**Application No: NWP/23/00020/PREF**

**Proposal: Replace glazing units and external doors to all addresses, propose replacing these with UPVC double glazed windows, and composite GRP cottage style doors.**

**Location: 10-13 Mackworth Green, Finedon, Wellingborough**

Drawing Title: Site A - Existing Elevations - Block 02

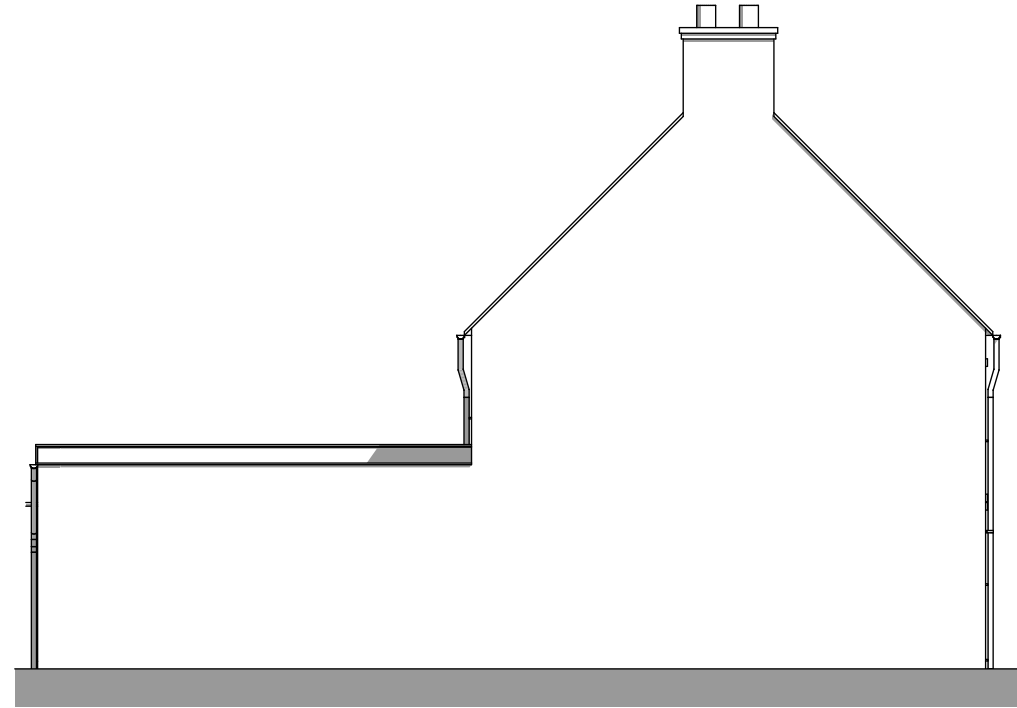
The existing planning history does not appear to include the replacement of windows which suggests the existing windows pre-date the date of listing (which is 1970) and may date from the early twentieth century. It is important to note that the first step is to assess whether the existing windows are of any special or historic interest and what, if any, contribution they make to the significance of the heritage asset. This

Drawing Title: Site A - Proposed Elevations - Block 02

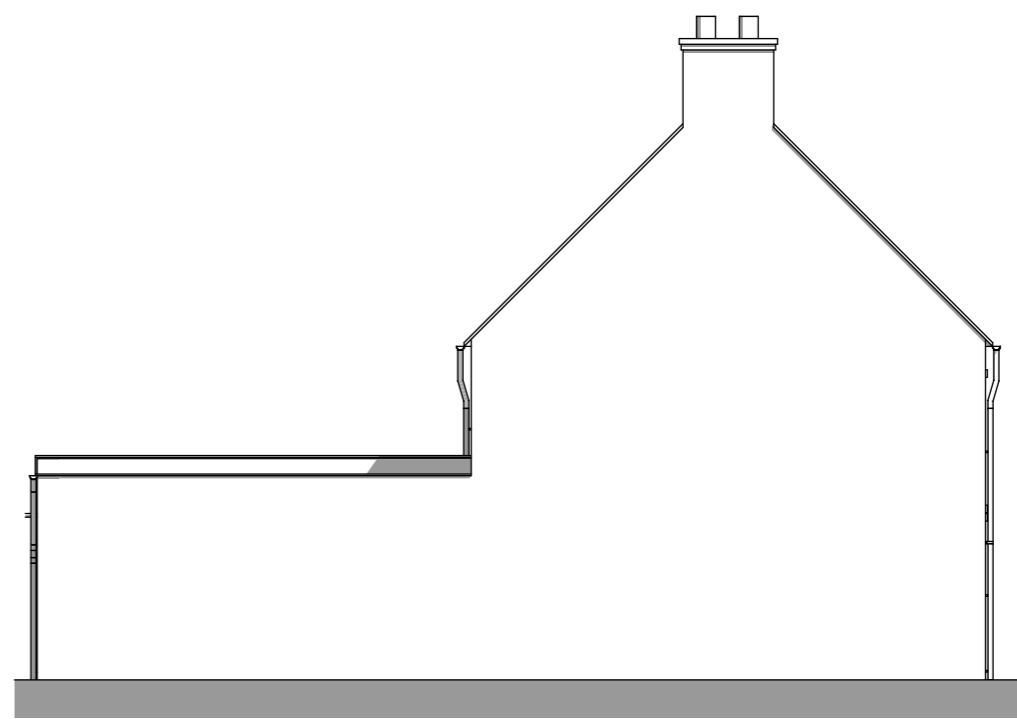
Should it be sufficiently evidenced that the windows are beyond repair, they should only be replaced on a like-for-like basis (this will include glazing type i.e. single glazing should not be replaced with double-glazing). If it is determined that the existing windows do not have any special interest, then a judgement must be made as to an appropriate replacement. However, non-traditional materials such as uPVC would be considered an unsympathetic and inappropriate introduction to designated heritage assets and traditional buildings and is unlikely to be supported. The existing cottage style doors are not considered to be of any special architectural or historic interest and, as such, the principle of replacement is established, subject to design, materiality, and external finish colour. Non-traditional materials such as uPVC or composite would be considered an unsympathetic and inappropriate introduction to designated heritage assets and traditional buildings and is unlikely to be supported'.

Accordingly, the proposals in their present form are considered not to comply with policy 2 (a) and (b) of the JCS or the NPPF.

NNC senior built heritage consultant considers that replacement with more traditional windows and doors that better reflect the original historical character of the building a more suitable replacement.
